**RE: Juan Tabo Hills Estates Preliminary Plat, Project # 1005278**

The purpose of this letter is to explain how the comments as contained in the DRB Official Notice of Decision (May 21, 2015) have been addressed. The following items have been revised and are being re-submitted for review and approval.

1. Preliminary Plat (including Sheet 1 Vacation Exhibit),
2. Infrastructure List,
3. Sidewalk Exhibit
4. Perimeter Wall Detail
5. Grading and Drainage Plan

GRADING & DRAINAGE PLAN

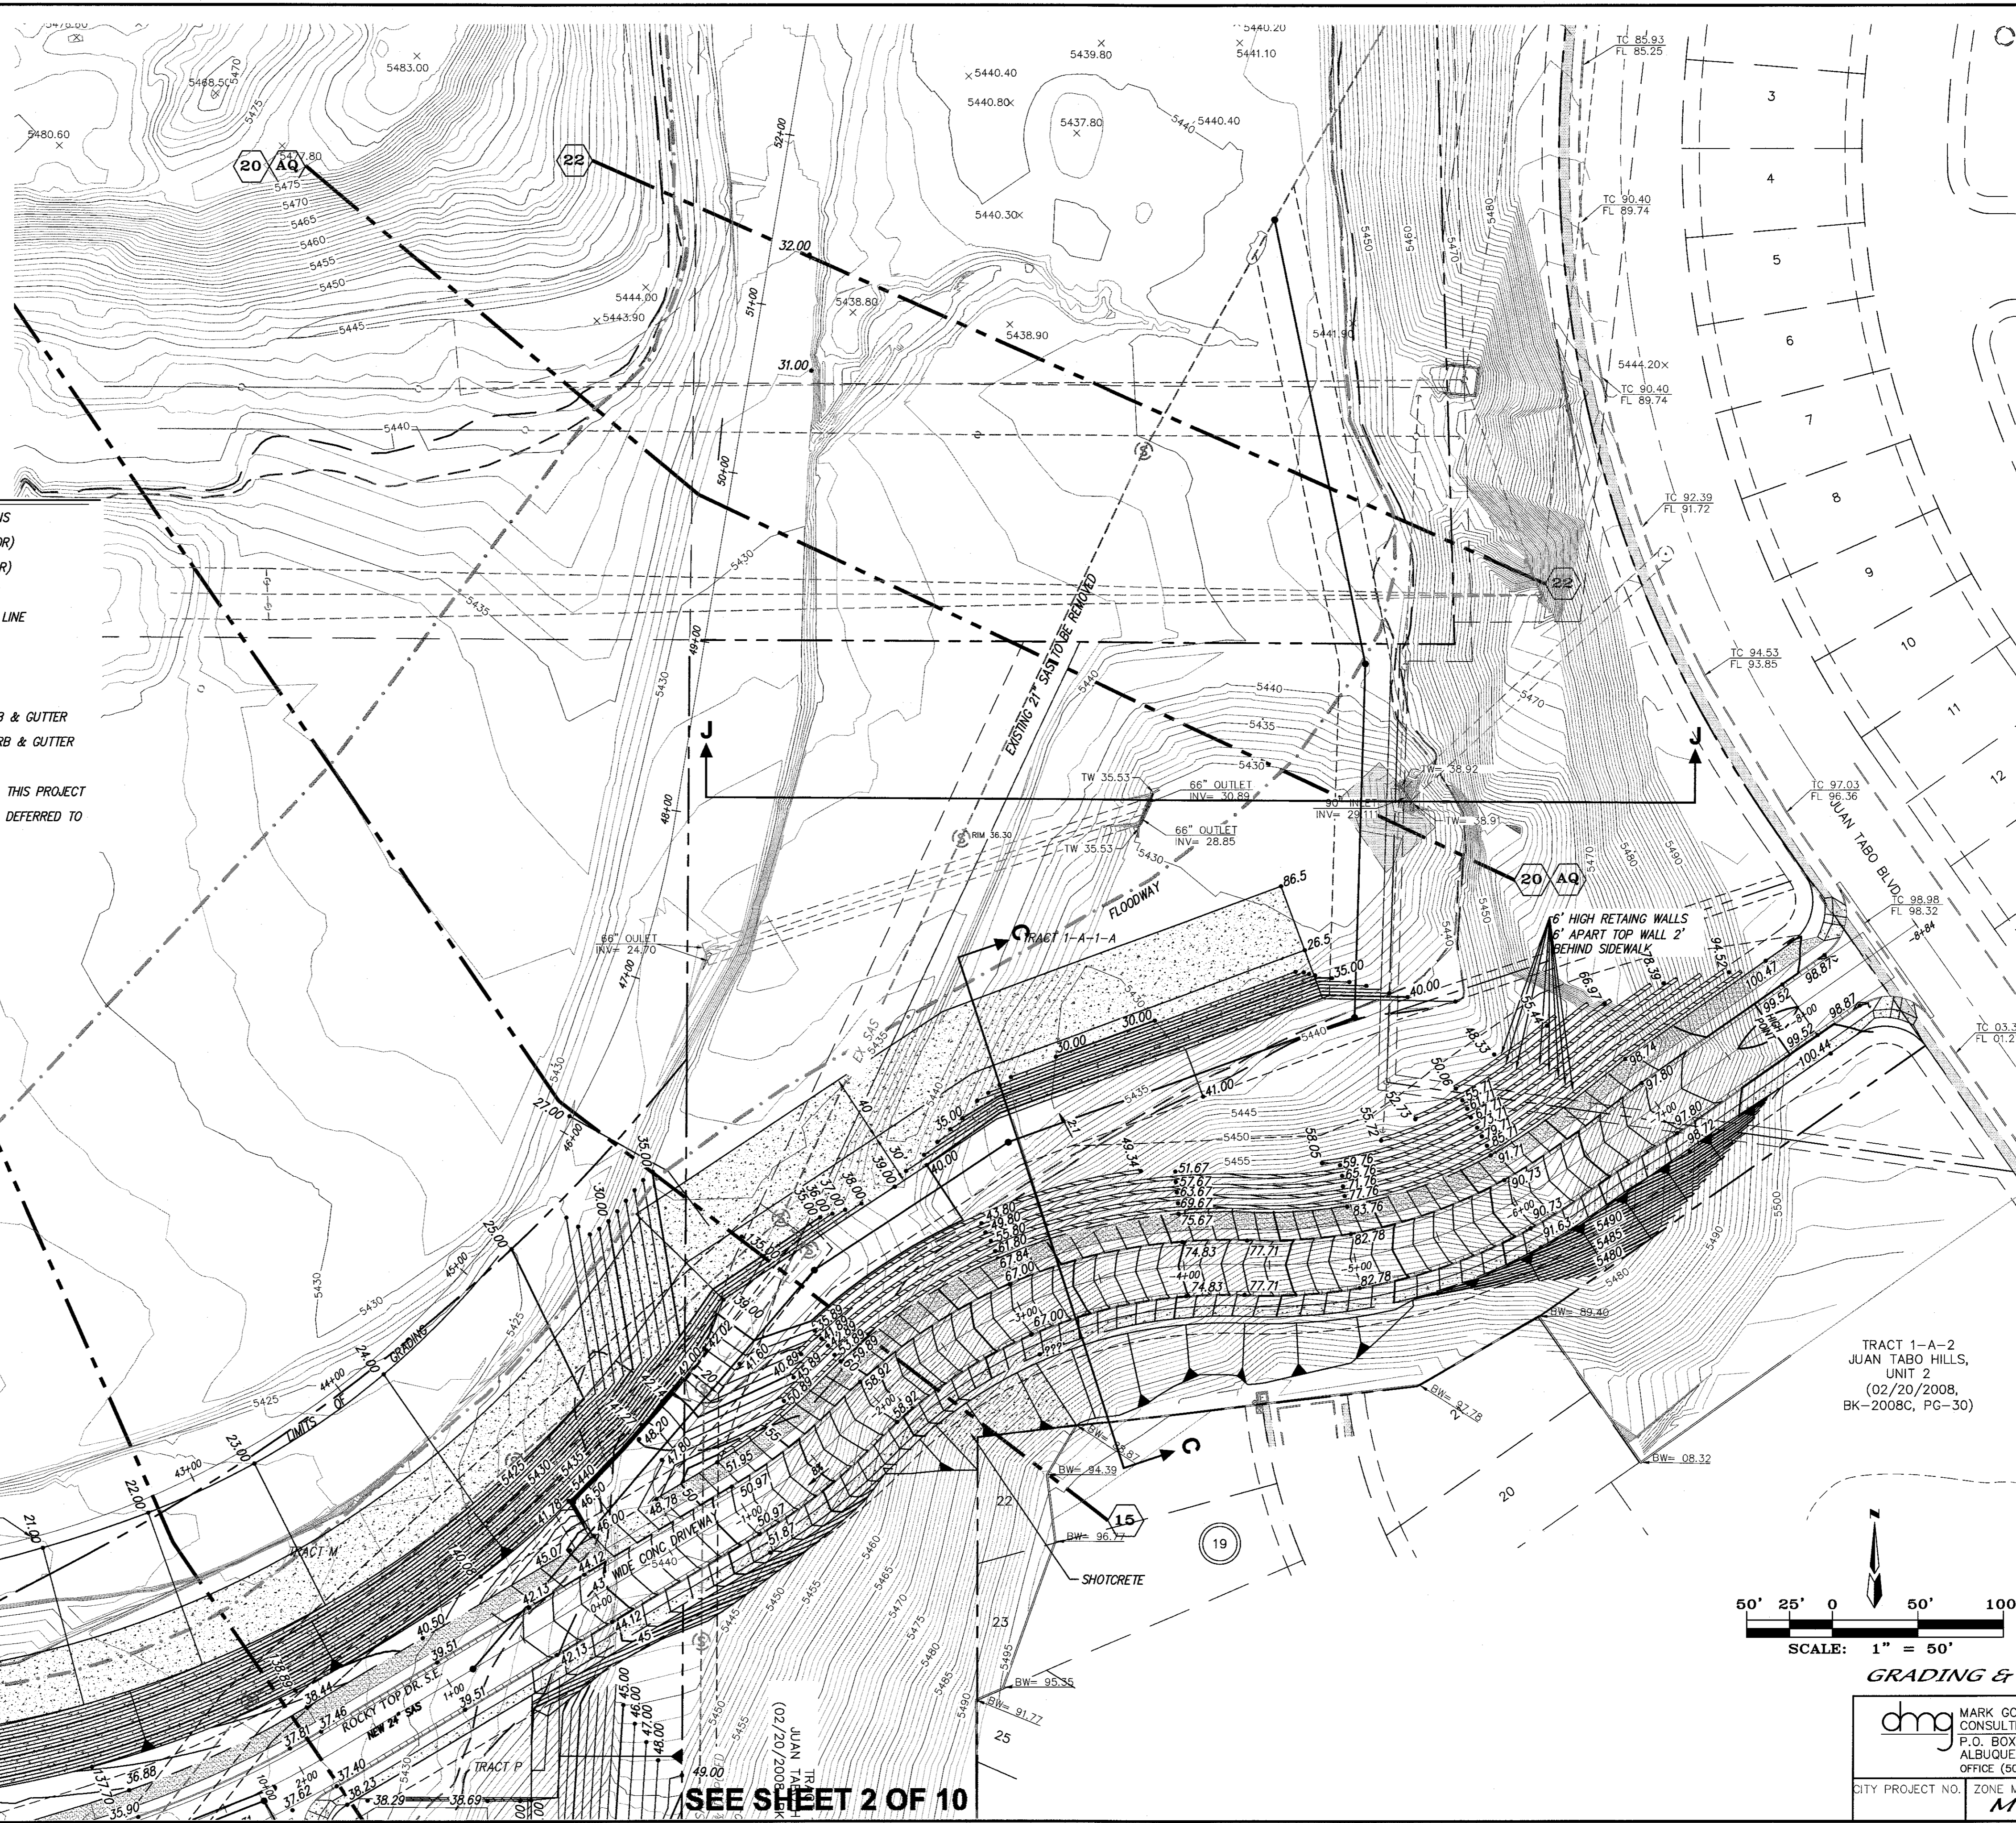
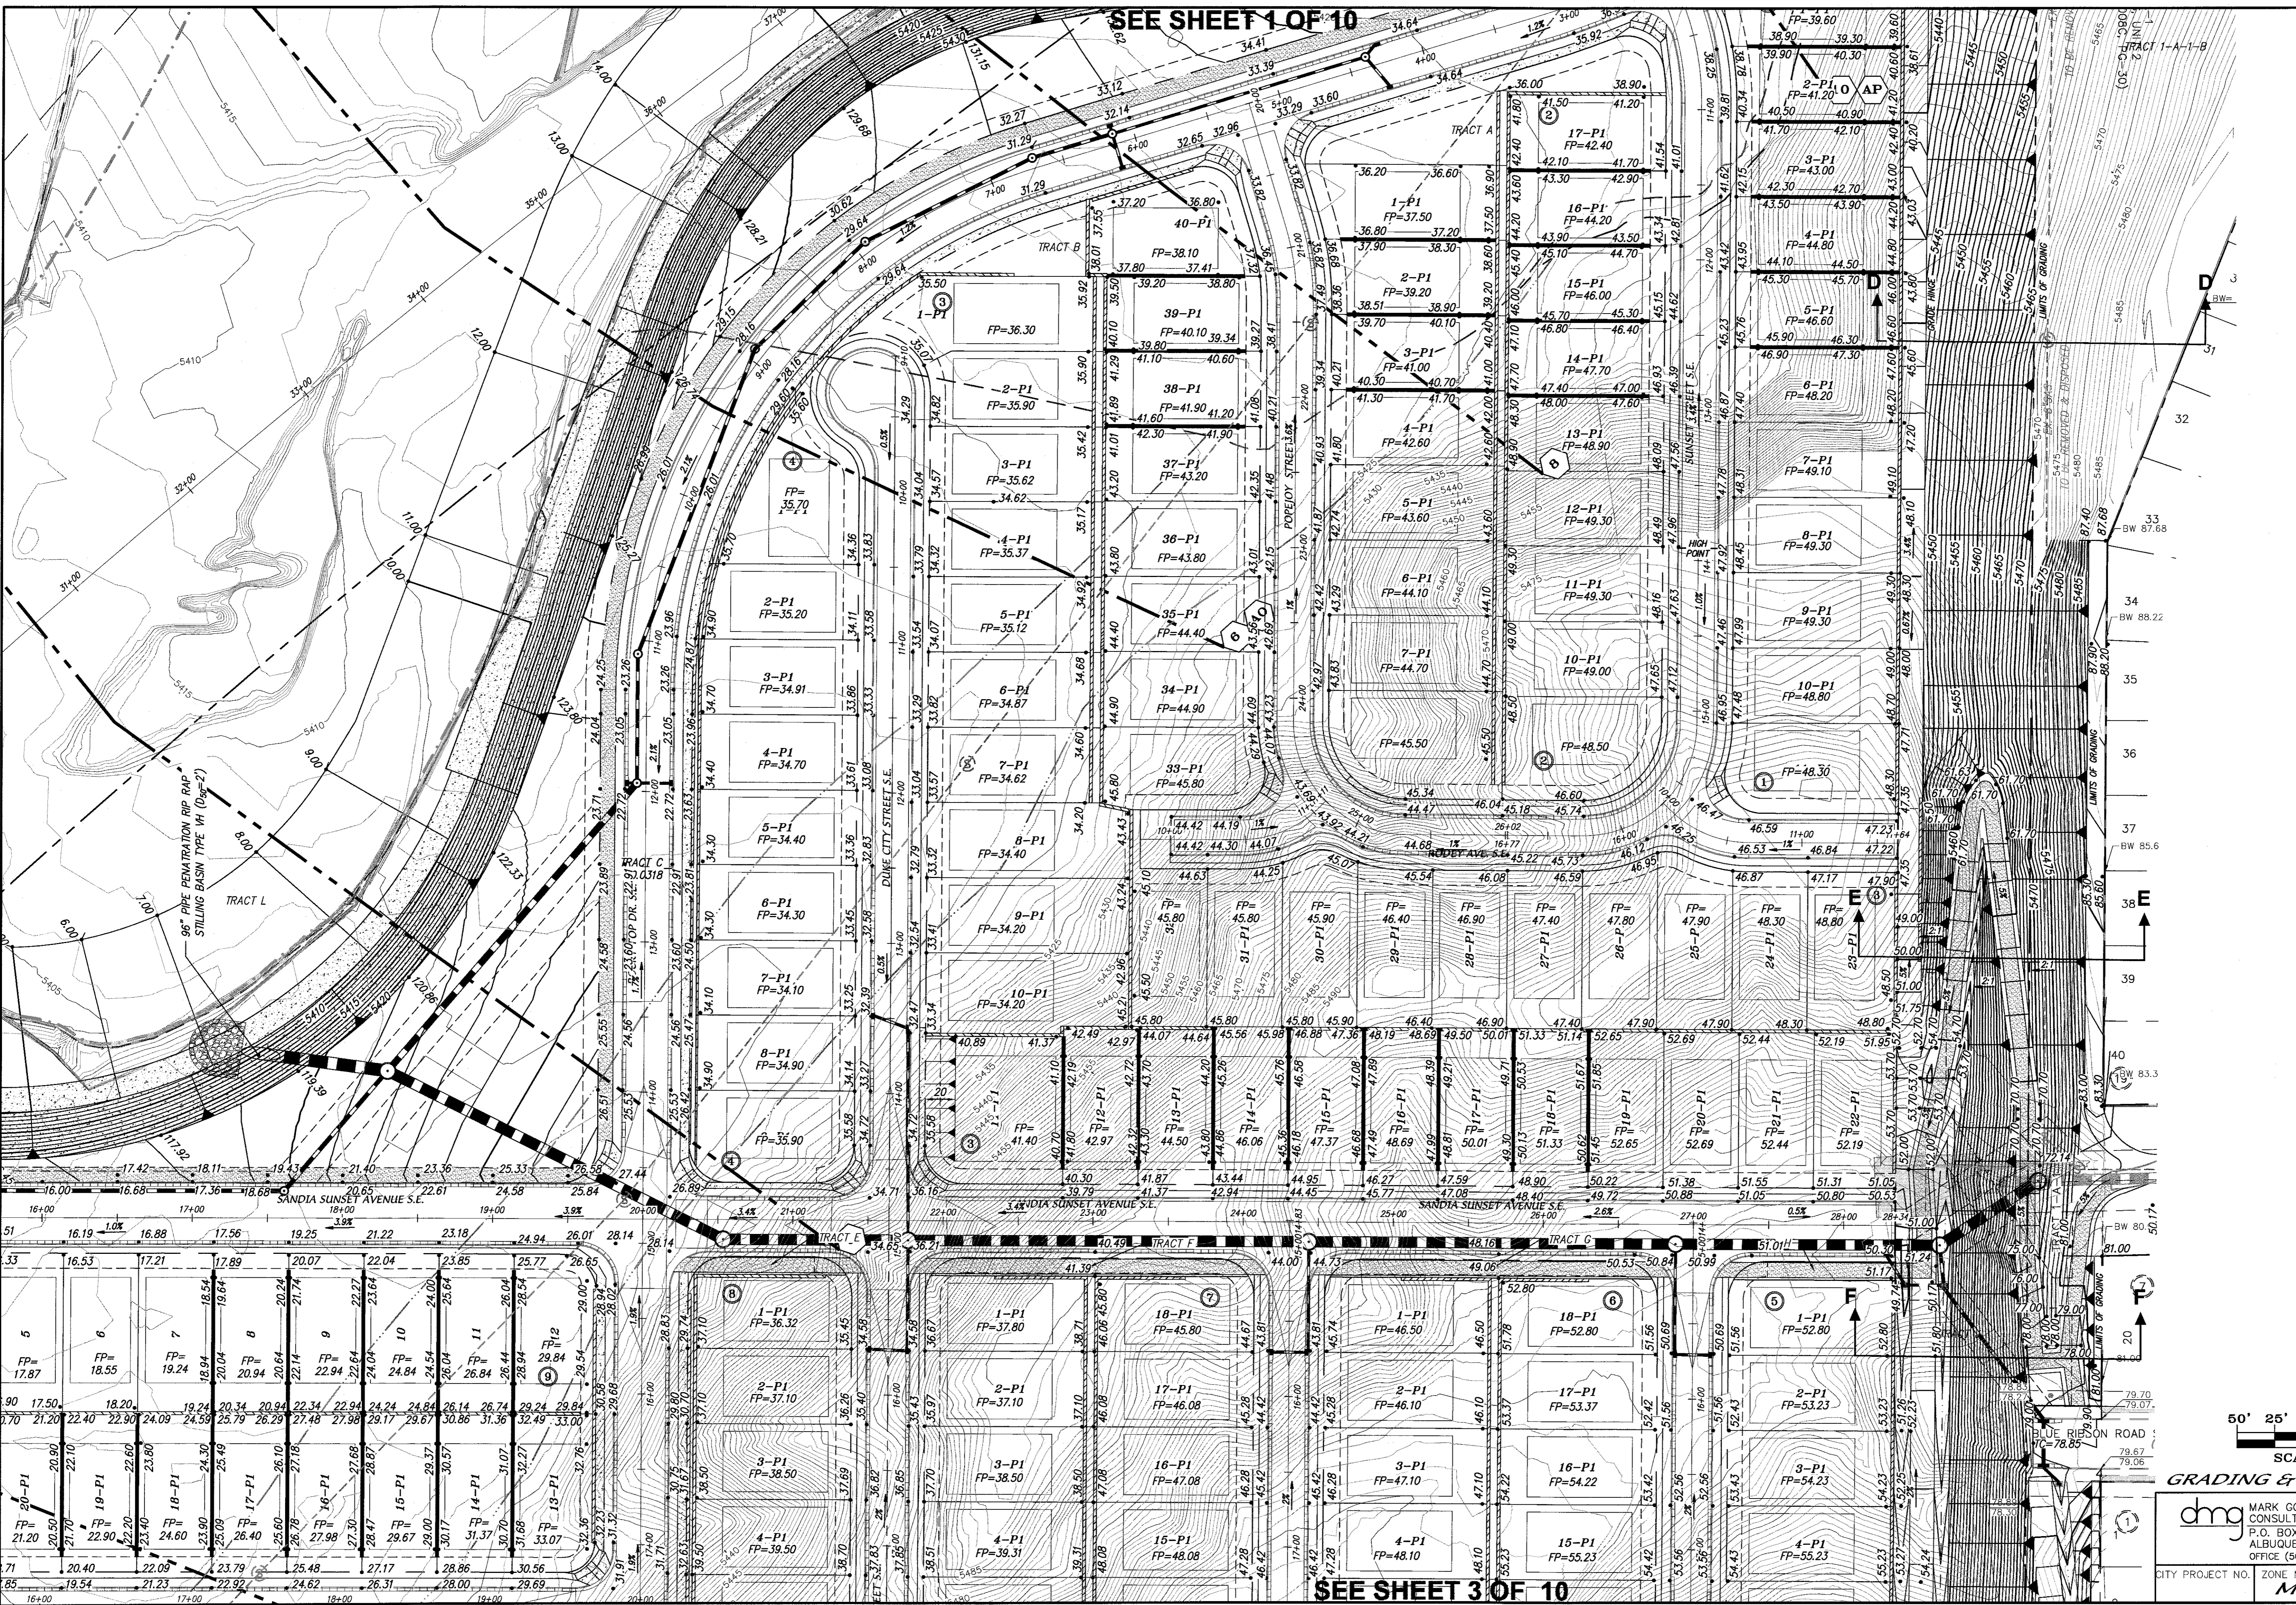
Parks and Recreation comments (1.) requesting changes to the landscape plan are now not applicable since the Landscape Plan and Tract A have been deleted from the site plan, though some separate exhibits have been provided to Carol Dumont to aid in her review. (2.) Previous agreement(s) say that the privately maintained Neighborhood Park is a private park which will be owned and maintained by the HOA. The private park is not subject to City review and approval and so has not been added to the infrastructure List (3.) The signature block on the infrastructure list has been changed to read Parks and Recreation Department. (4.) The Memorandum of Understanding between the USACE and the NMSHPO was distributed to DRB members during the first DRB meeting which outlines the approved plan of action for compliance with all cultural resource regulations (federal, state and local). (5.) The underground utilities are on the Infrastructure list and an updated copy of the Conceptual Utility Plan has been provided to aid in the review of the Infrastructure List. Contours and spot elevations have been

added to the Grading Plan. Separate permits will be obtained from the Corps of Engineers and AMAFCA that will address fencing along the arroyo. (6.) Ten foot wide AC Trails have been added to tracts H and J and are located in the best place available to insure privacy of the residents. AMAFCA has no objection to the approval of the Preliminary Plat and will be reviewing more detailed plans after Preliminary Plat Approval keeping in mind federal water quality standards and regulations.
